## Use of Innovation Plaza for Outdoor Seating SSD Modification

### Submission by the Rail, Tram and Bus Union Retired Members Association

The RTBU RMA opposes the requested modification for seating and tables for 220 pub patrons in part of the western side of Innovation Plaza. The Association argues the modification proposal does not meet the requirements of 4.15 and 4.55(1A) of the EPA Act.

Figure 1: Proposed extension of outdoor seating areas along Innovation Plaza

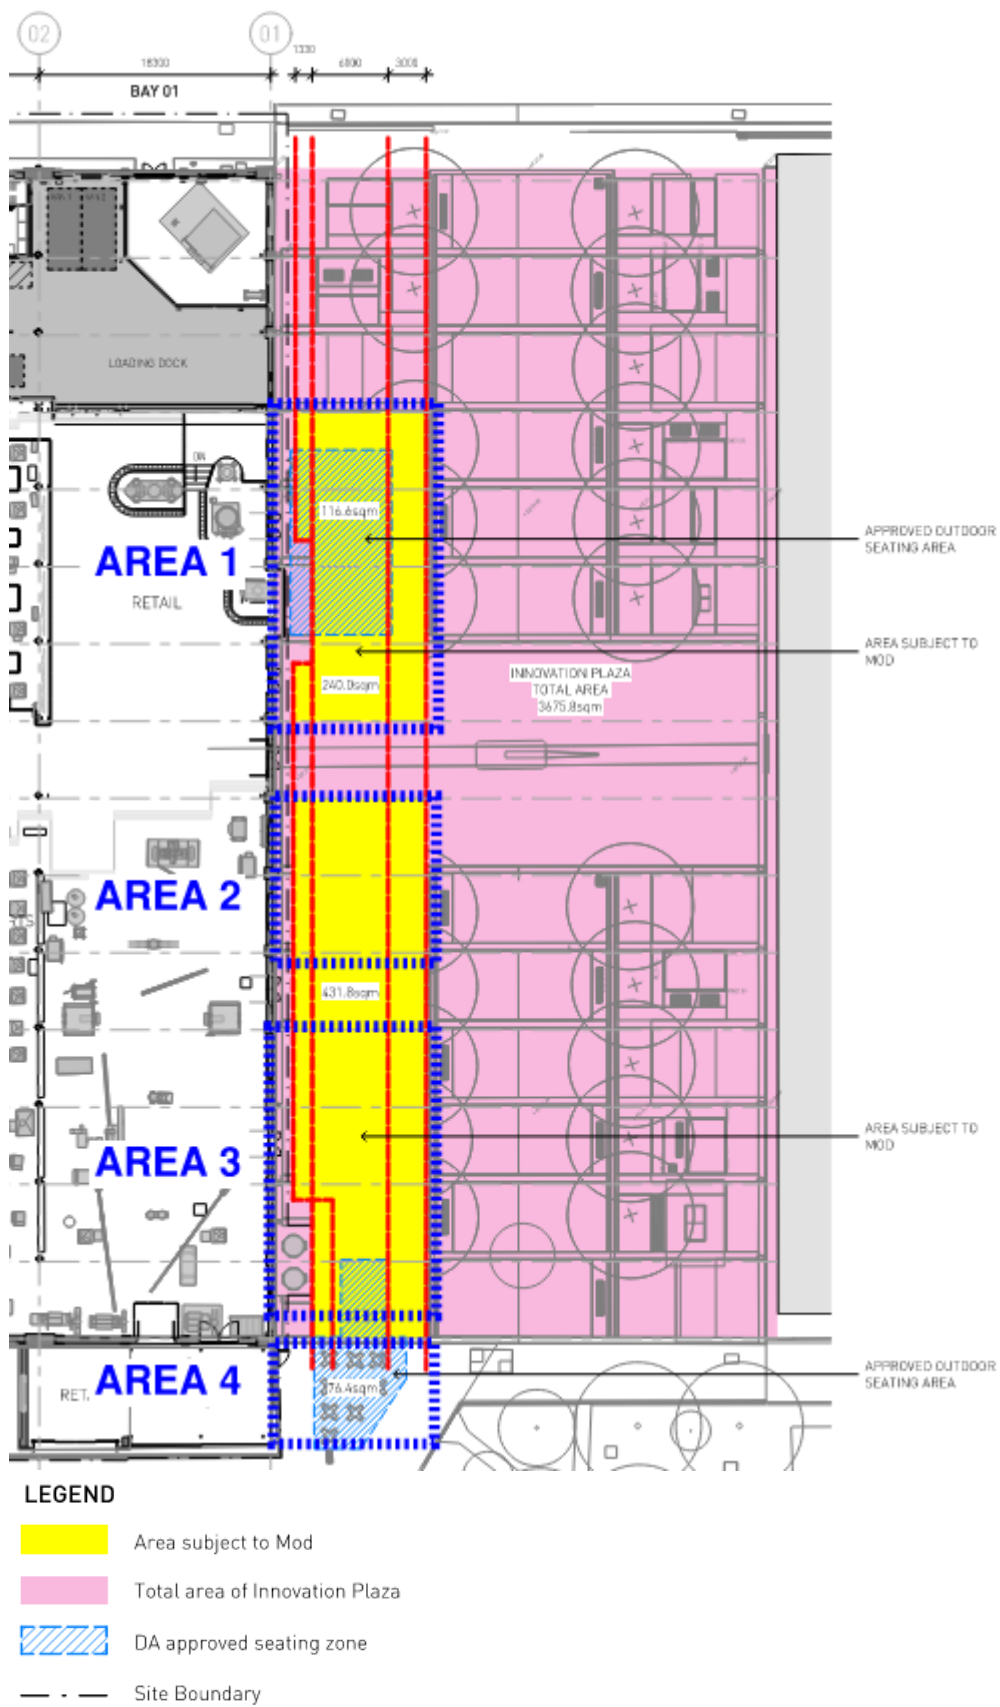
The application attempts to minimise the impact by referring to the seating areas as occupying only a small area of the Plaza or 16% of the total area of the Plaza. This figure fails to take into account the cumulative impact of SSD 8517 on the plaza including the impact of the Loading Bay. It completely ignores the fact that many activities and groups, particularly families will be deterred from using the plaza because of the presence of up to 220 pub patrons. The impact of the seating for 220 pub patrons will dominate the Plaza in many ways.

The applicant includes Condition A2. The proposed modification is to “*add drawing 00-04 which shows the indicative furniture layout.*” The Association argues this should not be allowed as it does not meet consent condition A19A (b) which requires “*the exact location, size ,number of patrons/seats etc*” The same issue applies to proposed A19 B. the Association notes there are many examples in SSD modifications where the lack of exactitude has led to different outcomes.

- The original SSD application was for a seating area of 300 square metres which in broad terms allows for some 100 seated patrons. This is some 50% of the area of the seating /patrons the current modifications seek approval for.
- The retail premises that are now located in Bay 1 differ markedly from what the applicant sought in the original SSD 8517 application. That application sought
